From: Jacqueline Aggiss
Sent: 11 March 2020 09:44
To: Plant, Tom - Communities
Subject: 19/02001/F - The Chaff Place, High Street, Bodicote

I am in receipt of your latest comments in respect of the above application for two dwellings. It was requested a speed survey should be undertaken to determine the visibility splays. The speed survey results are attached and the visibility splays based on the speeds are shown on the attached plan. The splays can be achieved from a 2.4m setback in both directions.

SITE PLAN
(Scale 1:200)

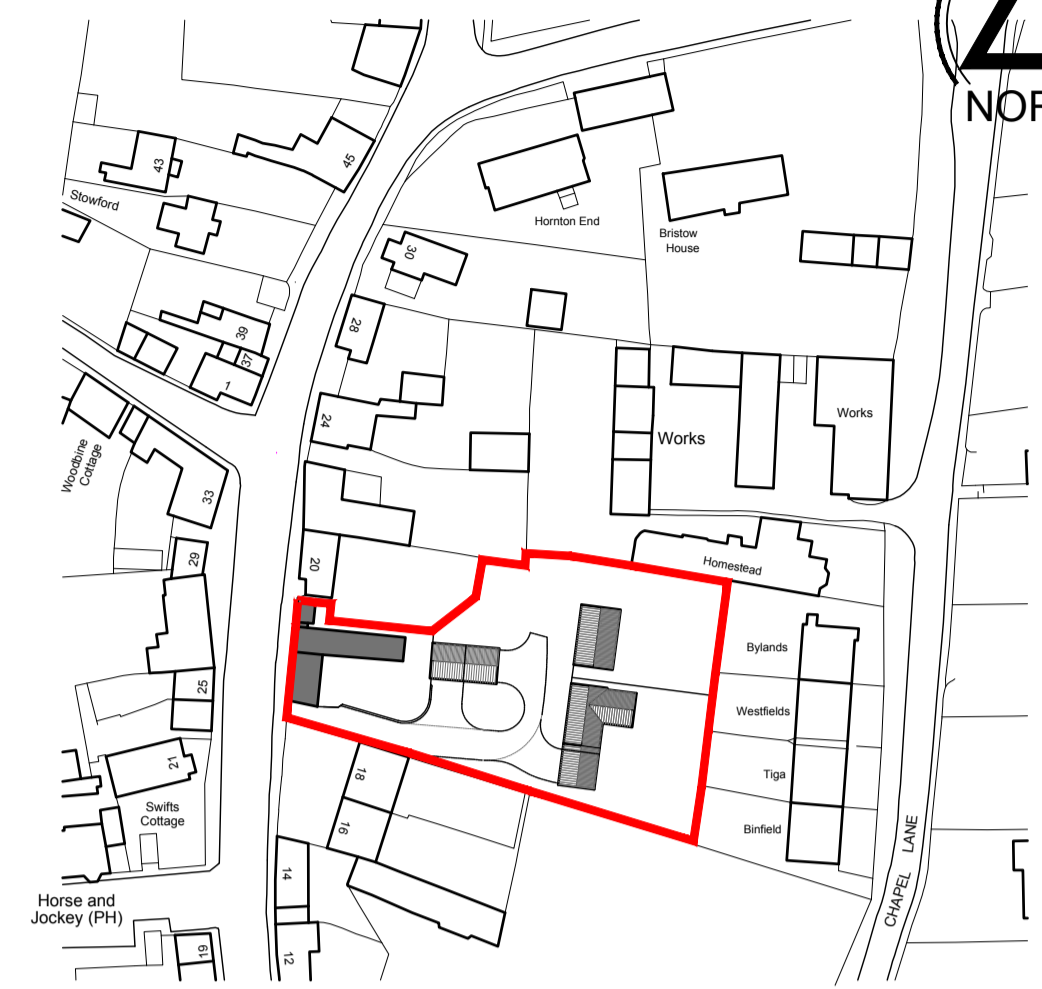
To overcome concerns with the geometry, the access road is to be widened inside the site to 4.8m with a passing place to allow two cars to pass. This was included in the application documentation and is attached for completeness. As such it is very unlikely a vehicle will be required to reverse out of the access. I also understand the existing gates across the access and pillar has been removed and the access width is now around 3.8m. The previous consent was based on an access width of 3m.
